***MODIFICATION REQUEST:
Hurstville Private Hospital
37 Gloucester Rd, Hurstville
(MP11_0042 MOD 1)***

Director-General's
Environmental Assessment Report
Section 75W of the
Environmental Planning and Assessment Act 1979

March 2014

**VIEW 5: ELEVATION AT CARPARK AND PROPOSED STORAGE DECK**

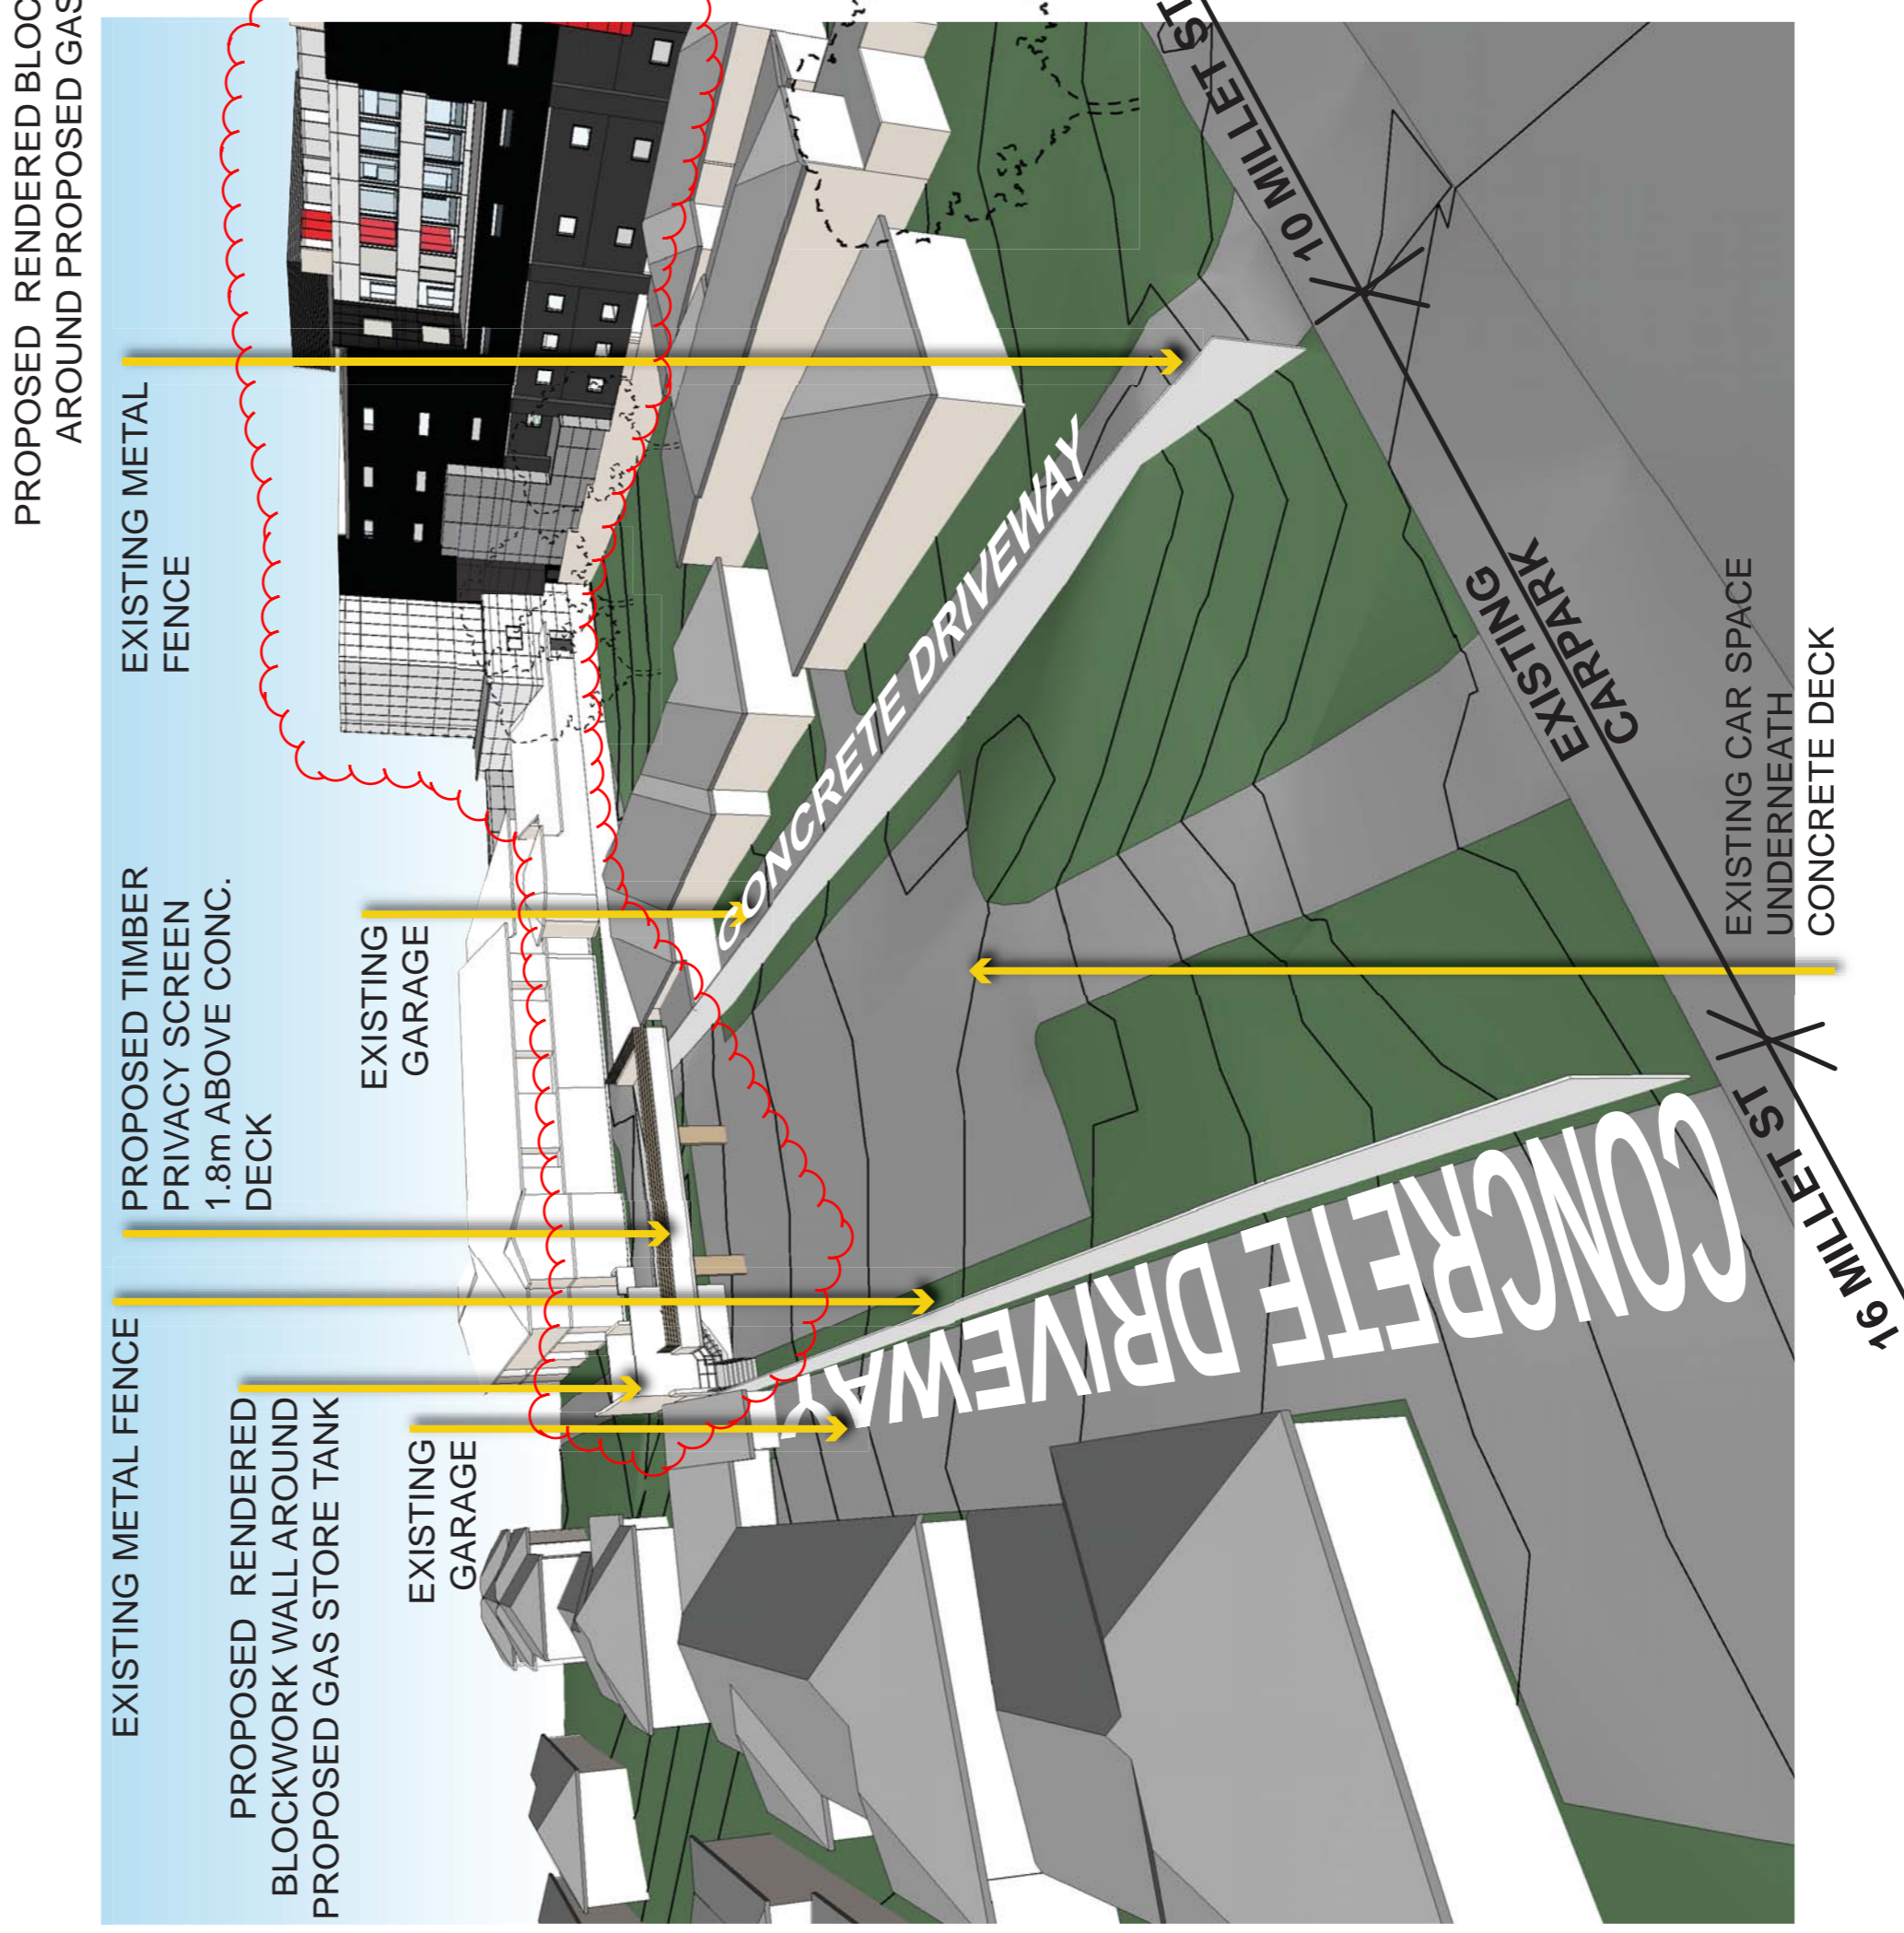
The modification application seeks approval to relocate the oxygen tank back to the originally proposed location on the upper deck at the rear of the 12 Millett Street car park, in a rendered blockwork enclosure, with vehicular access and servicing provided from Gloucester Street.

The modification application has provided justification (on safety grounds) for relocating the oxygen tank back to the car park deck of 12 Millett Street, namely:

- in order to minimise hazards associated with the location of oxygen tanks, it is recommended that gas stores to be located outdoors in a secure tamperproof cage protected from the sunlight; and

- expert advice provided with the modification application also detailed that the location of the gas tank in the loading dock (as required by the original approval) was unsafe during the refilling process as the tanker and the vessel would not be in direct line of site throughout the refilling process.

In order to ensure that there are minimal adverse noise impacts on residential neighbours, refilling of the tank will only be undertaken every fortnight on weekdays between 10 am and 3 pm. The enclosure will also be appropriately screened and will have no adverse impact on the outlook of adjoining residential buildings.

The agency is satisfied the relocation of the oxygen tank will not compromise safety or residential amenity.

TITLE: PROPOSED UPPER BASEMENT PLAN

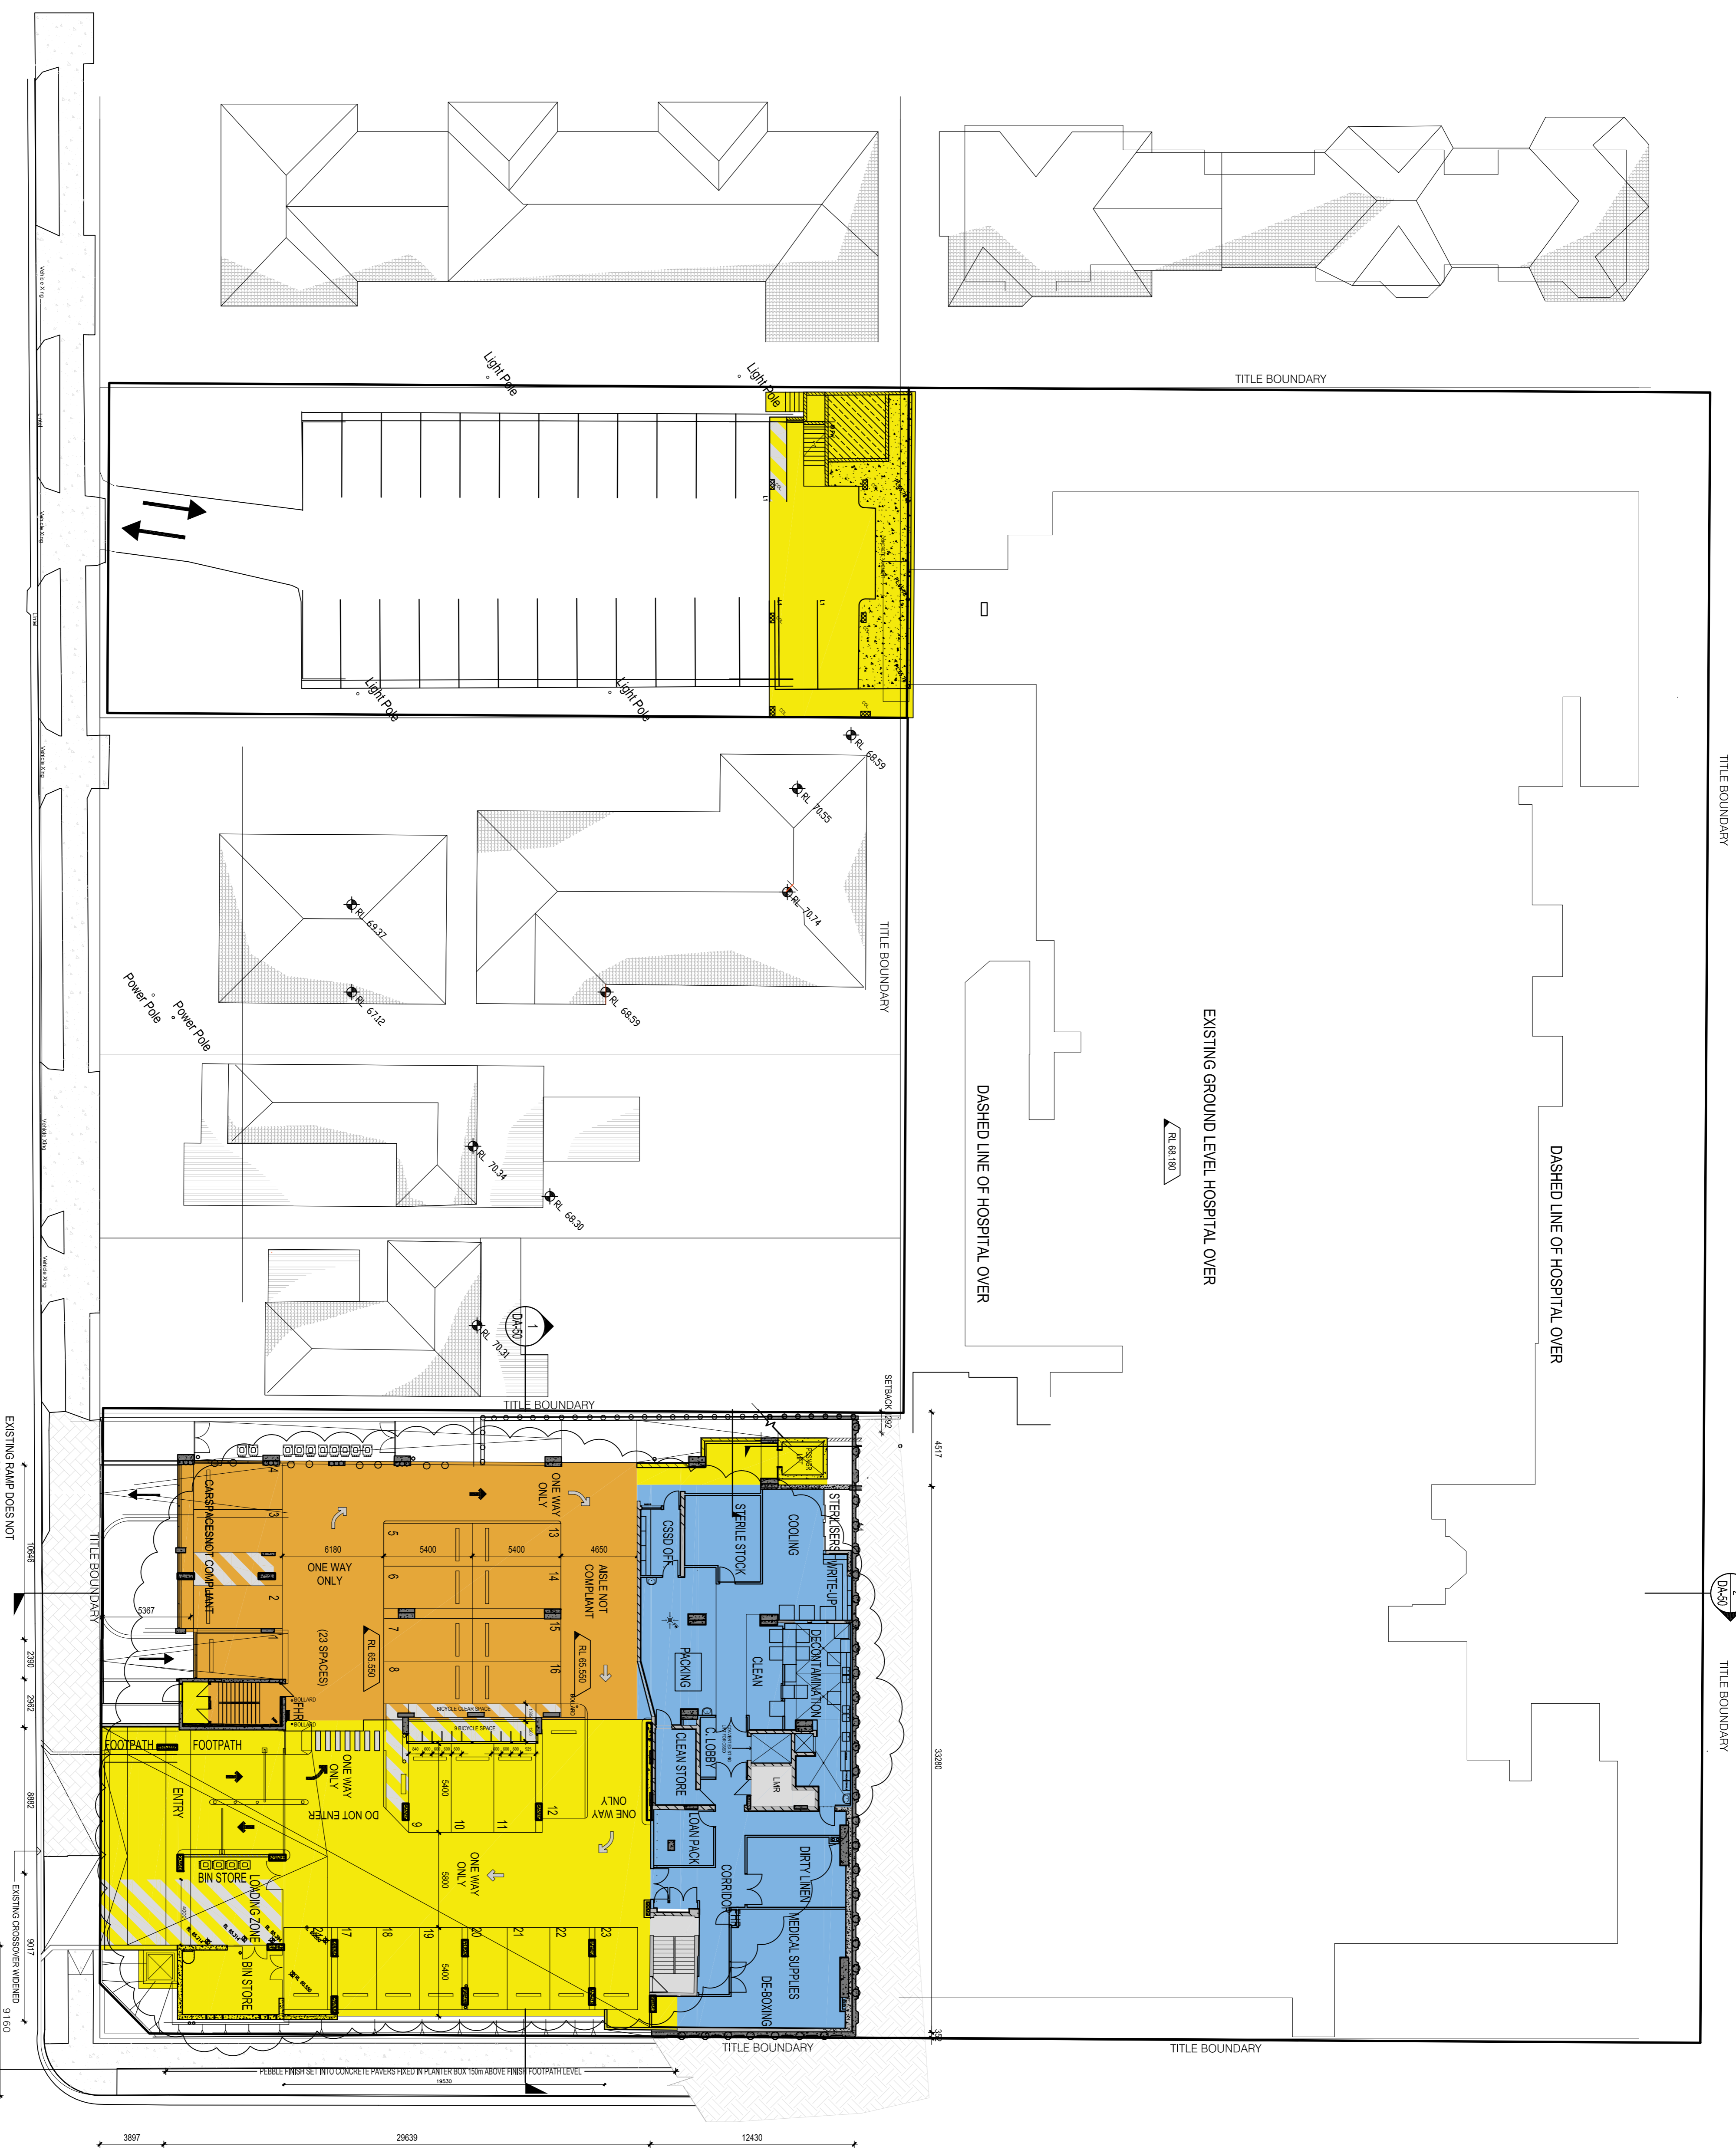
- the basement aisle widths do not comply with Australian Standards. If possible the widths should comply. If this cannot be achieved then the plans should be checked by a traffic engineer to ensure safe manoeuvrability;
